Info Only: Engineering
comments are in blue
text.

**PRELIMINARY DRAINAGE REPORT
FOR
URBAN LANDING
PRELIMINARY PLAN**

Job No. 1308.01 PUDSP243
PCD File No. ←

DRAINAGE MAPS

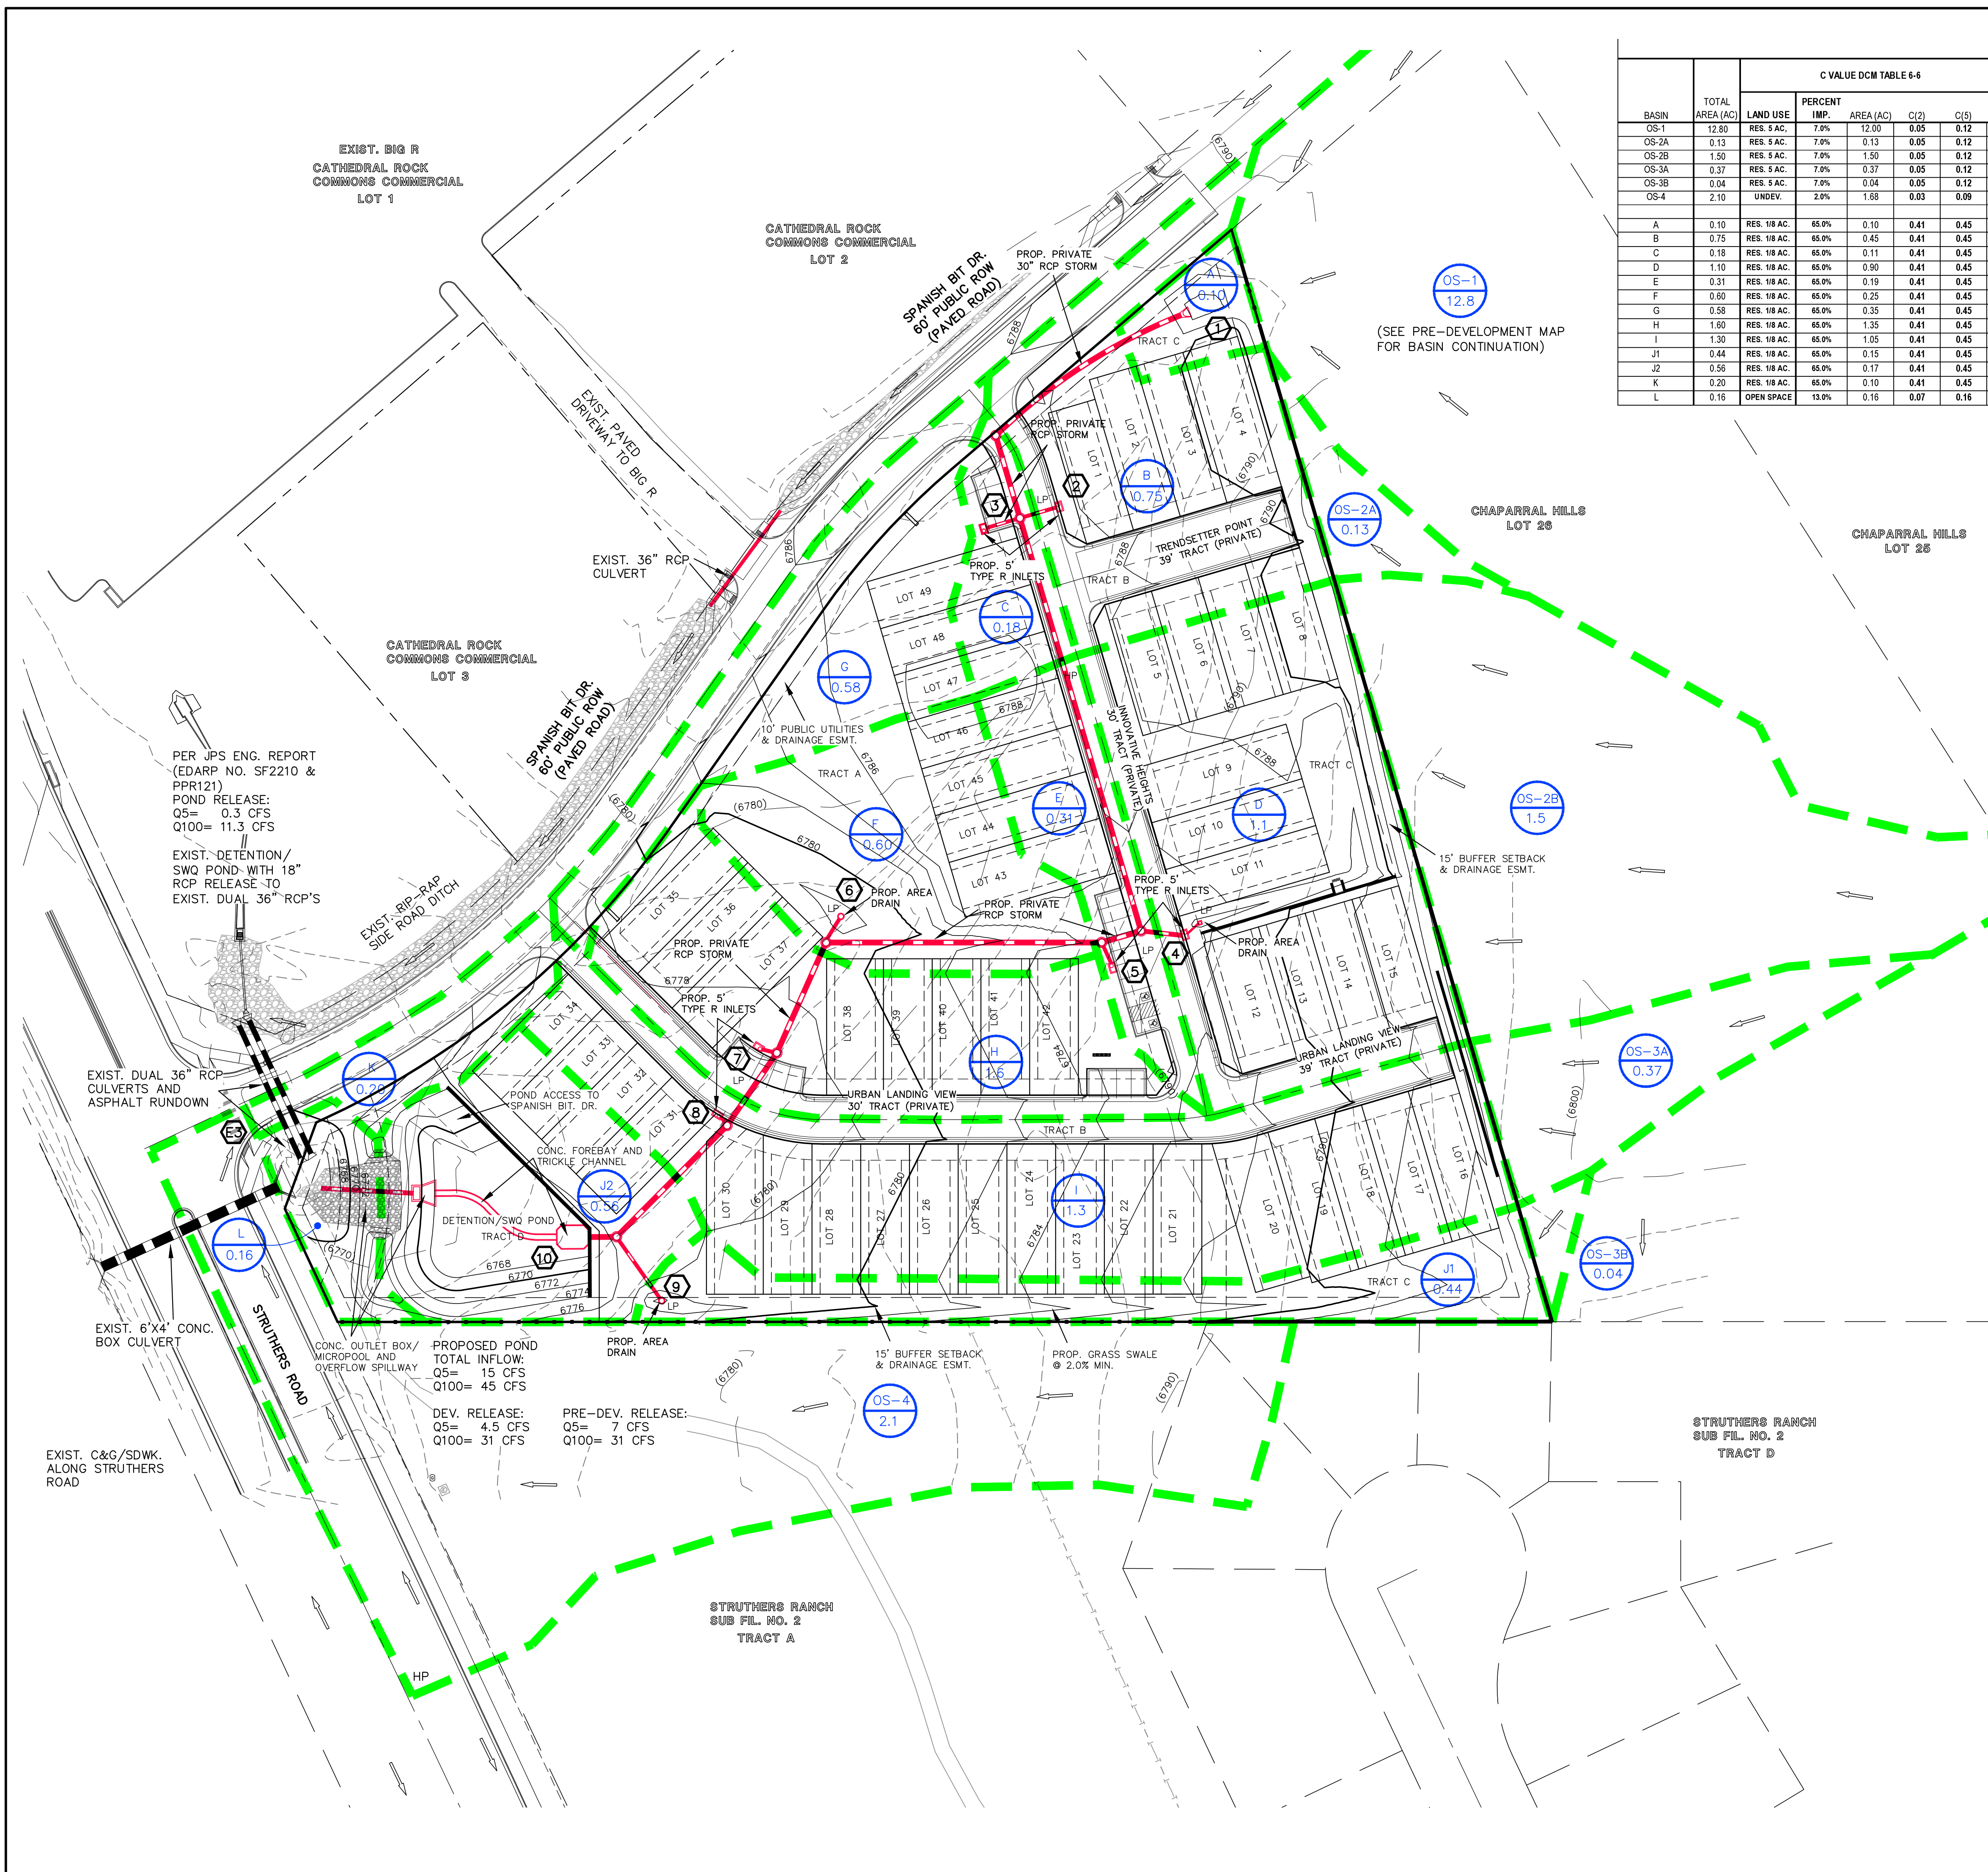
Please discuss emergency overflow path of all sump inlets in the case that the inlet becomes fully clogged.

Concentrated flow from the proposed swale cannot be discharged directly into the proposed pond. Please provide a riprap rundown.

Please discuss whether the existing culvert and existing holding basin have sufficient capacity to handle the increased runoff flows. Calculations will be required in the Final Drainage Report.

Please compare the discharge leaving the site in the existing condition with the discharge in the proposed condition.

Please discuss the design point where the discharge leaves the site. Please also discuss if there is a suitable outfall. Additional comments may be generated once the initial comments are addressed.
